PLANNING APPLICATIONS AND S106 OBLIGATIONS

Reference A. Planning Application 19/02550/F
B. Planning Obligations 21/03164/OBL

DRAWING SCALE: 1:125 @ A1	BICESTER HOTEL, GOLF & SPA	DRAWING NO: BICE.306
DRAWING SCALE: 1:250 @ A3		DRAWING REVISION: /
ORIGINALLY ISSUED: 17/08/2021		DRAWN BY: W.A.S.
REVISION ISSUED: /		CHECKED BY: H.A.J.S.

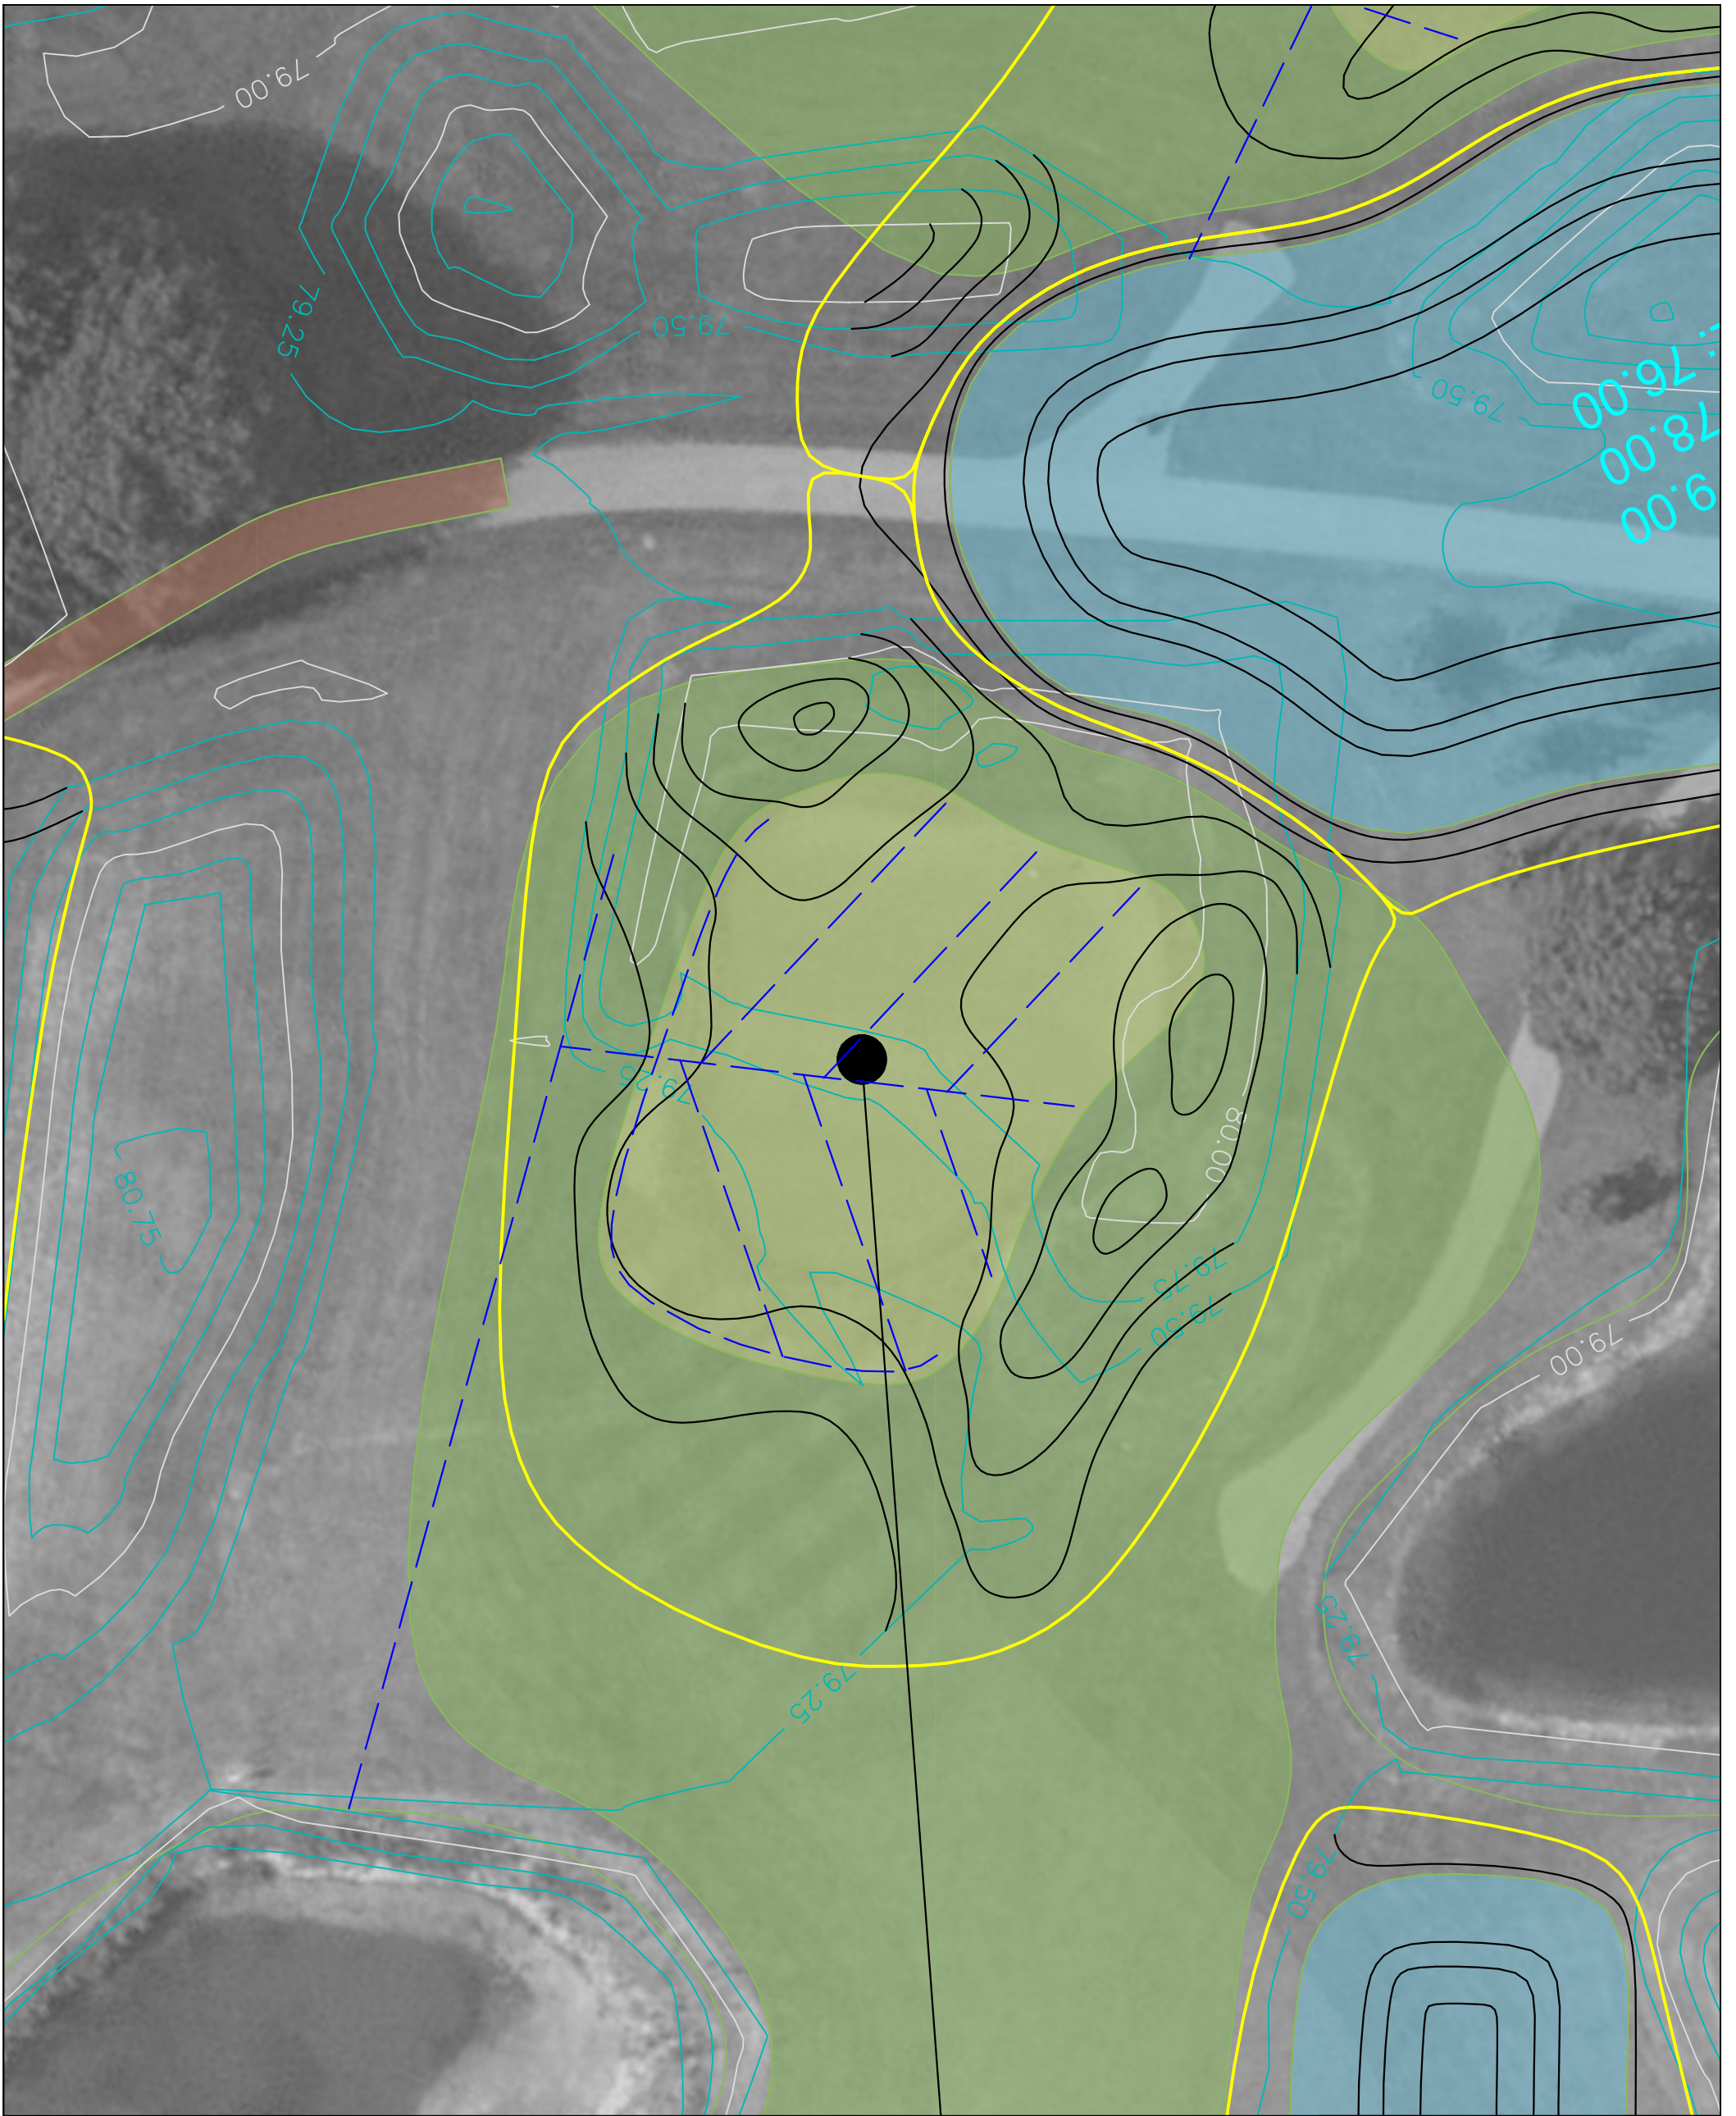
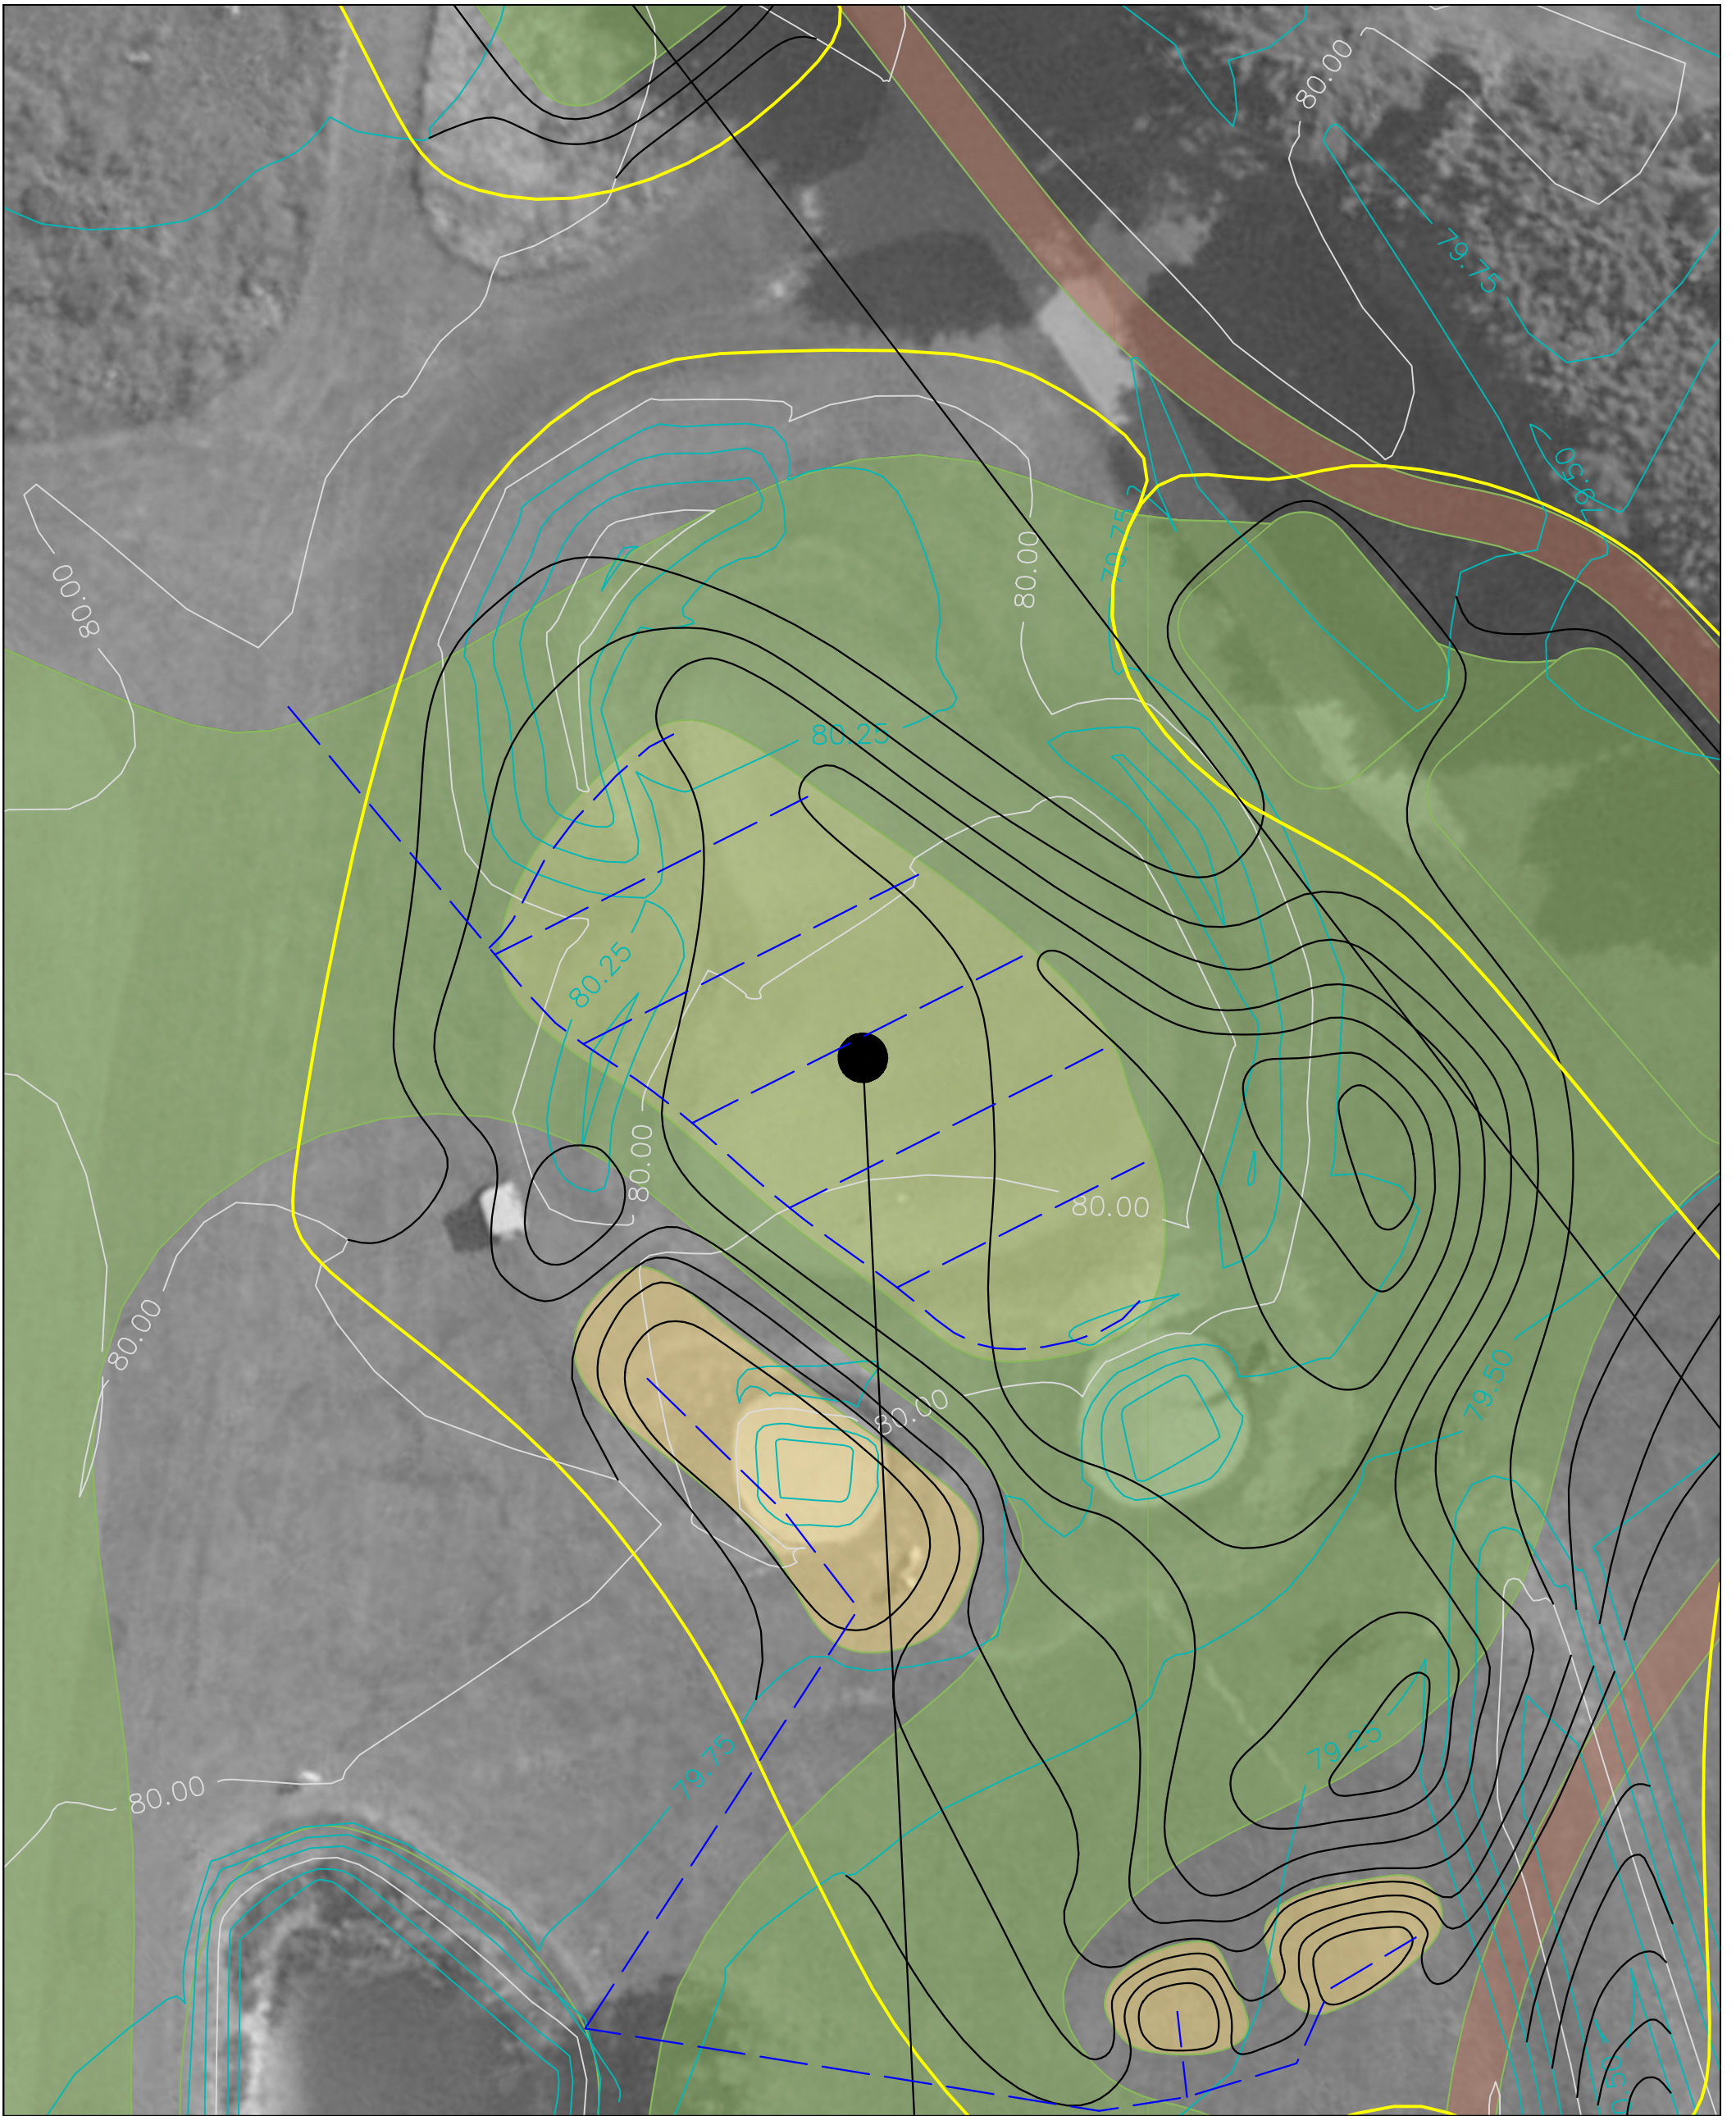
1. In particular they fail to properly address the matters of Health and Safety regarding the crossover points of golfers on the proposed new golf course layout. They do not provide any plan for the holes 10 to 18 where conflict when playing different circuits occurs. The only course plan provided is for holes 1 to 6. It seems their plan has not been submitted to Golf England for over-site and approval, yet the designer say it's an improved golfing facility. This is insufficient information for discharge to proceed.
